CLITHEROE TOWN COUNCIL

3/2012/1085; 1088; 1093; 1113;

Furthermore, the Town Council wish to ~~comment on the~~ ~~object to~~ application 3/2013/0014 - Land adjacent to St Paul's Church, Edisford Road, Clitheroe - Outline application for residential development as follows: -

Proposed Site Layout

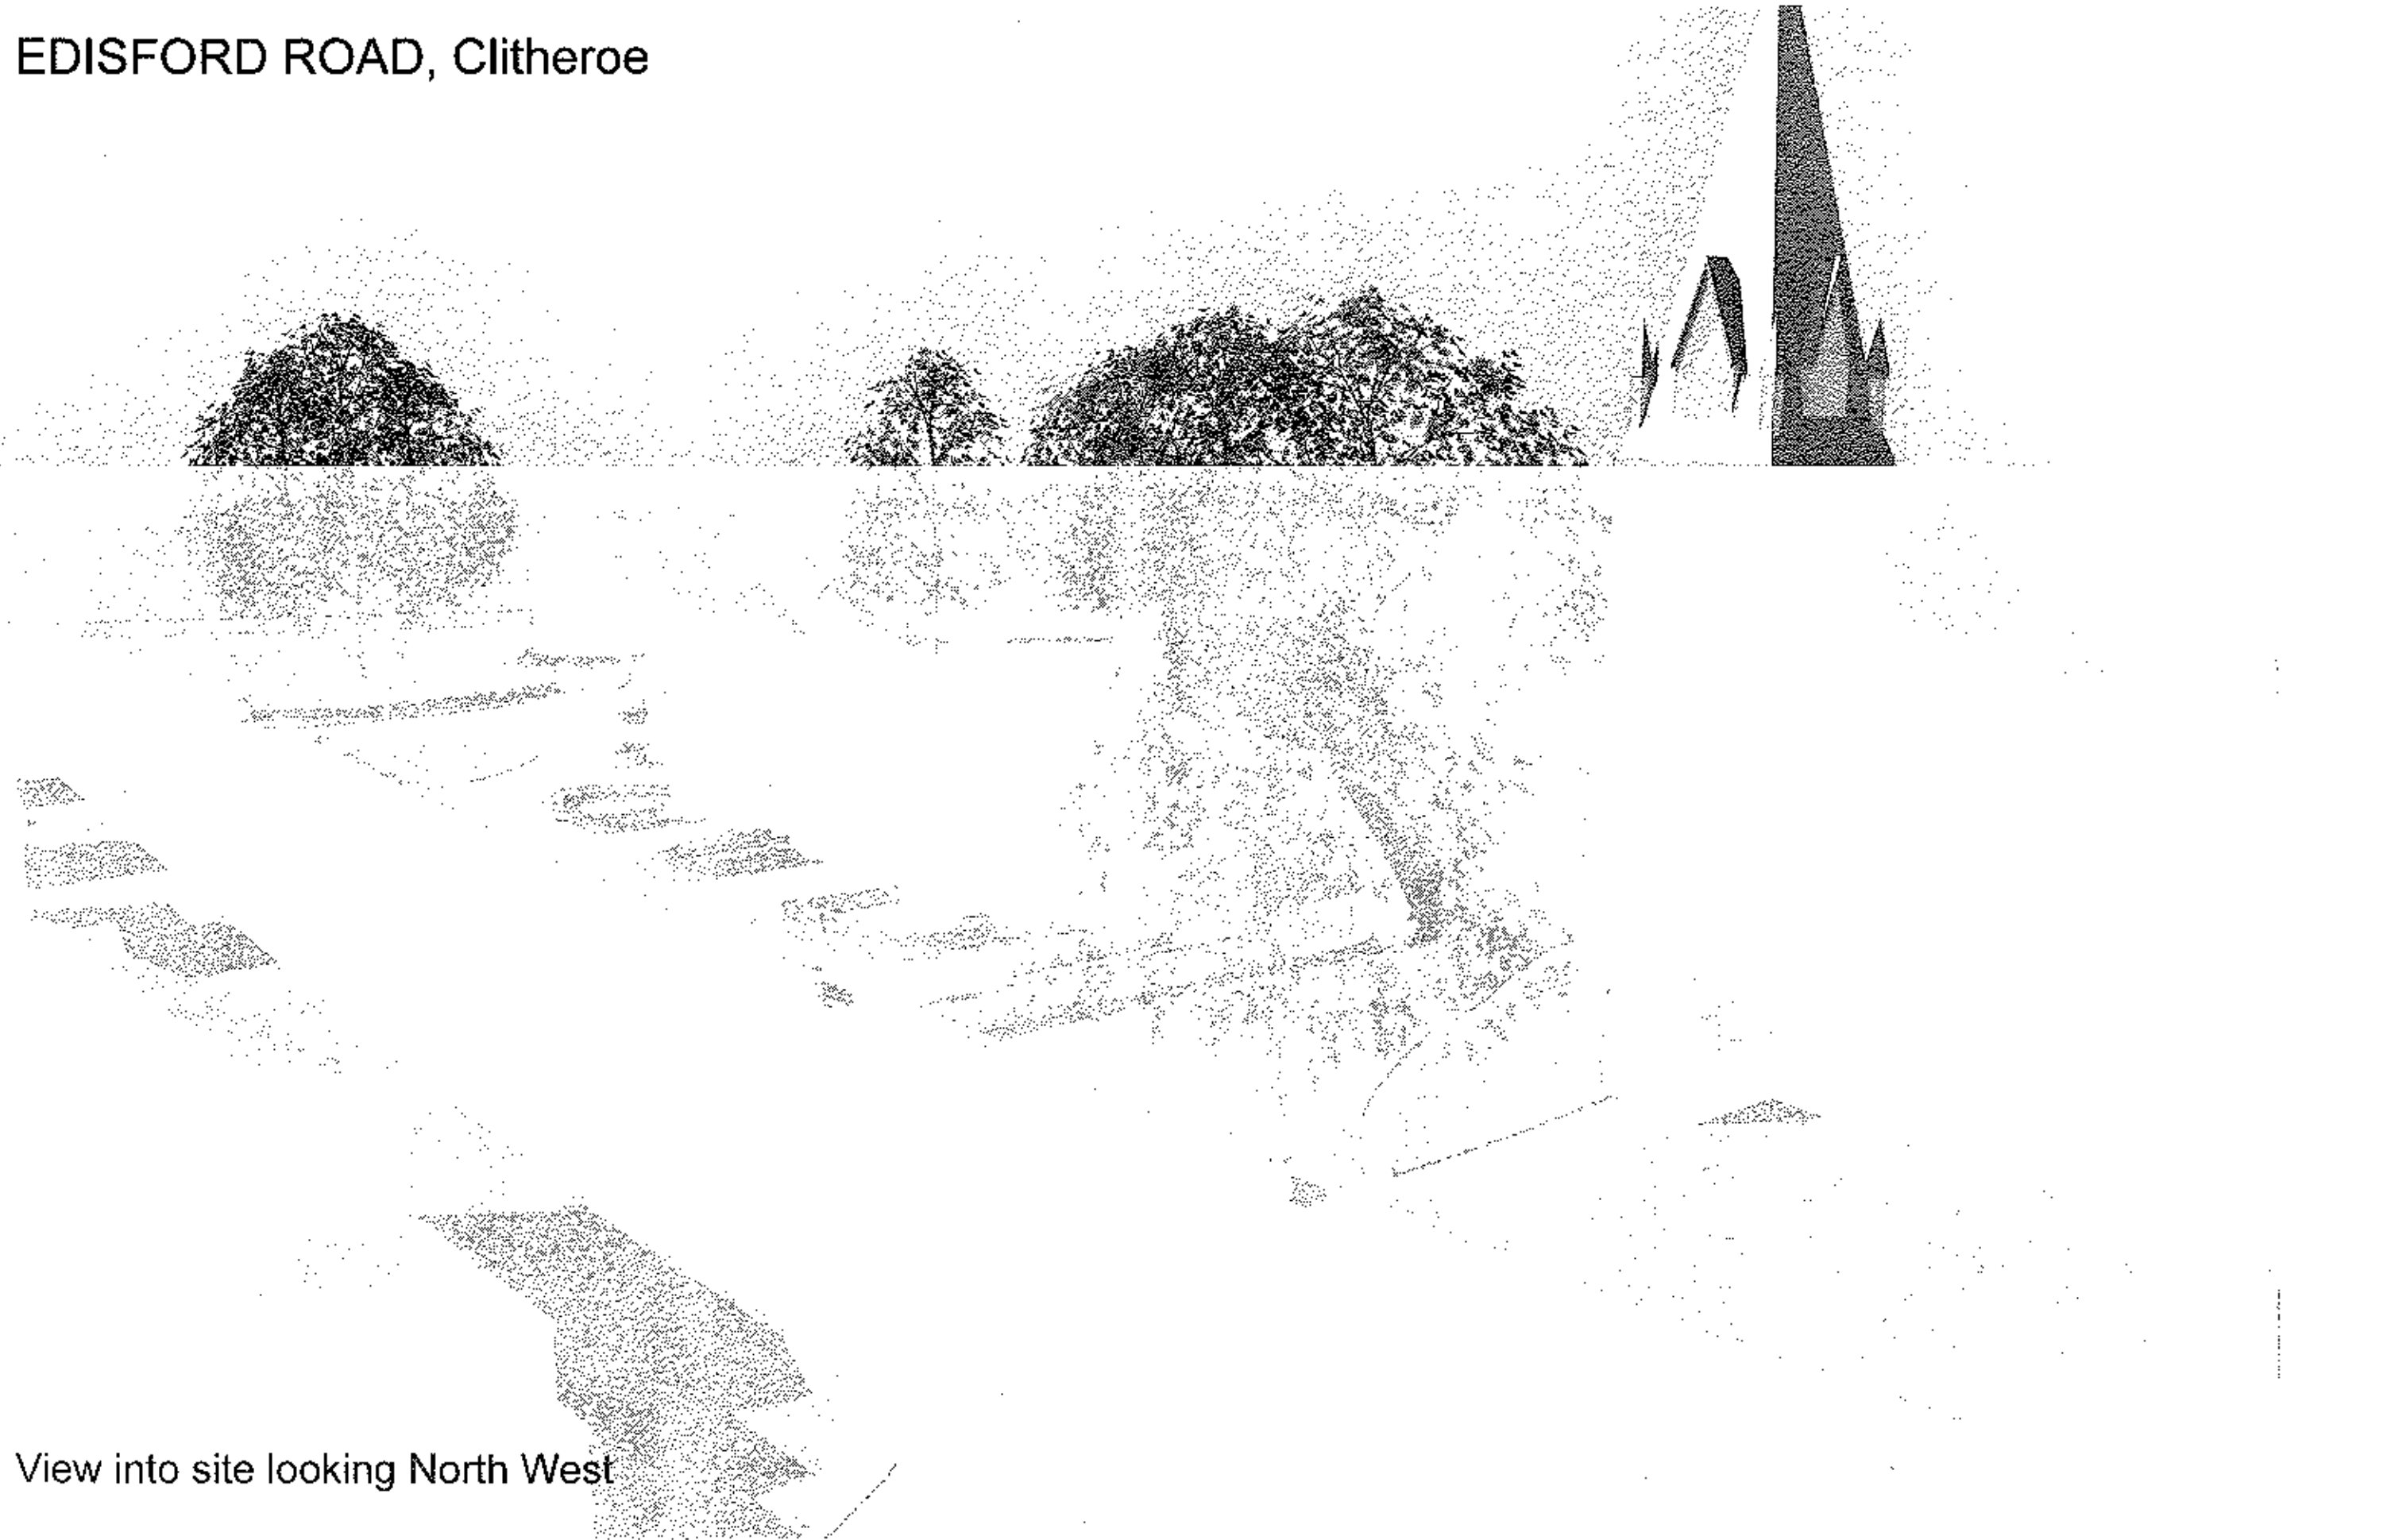
(a) Whilst they have no objection to the application they are disappointed that the proposal is now to construct 8 properties whereas the original proposal was for 9. (PTO).

this means that there is no longer a requirement to provide affordable housing; and that

- (b) The Town Council are unhappy with the proposals contained in the application to provide access to the development site directly from Lidsford Road. They consider that access should be from St Paul's Terrace.
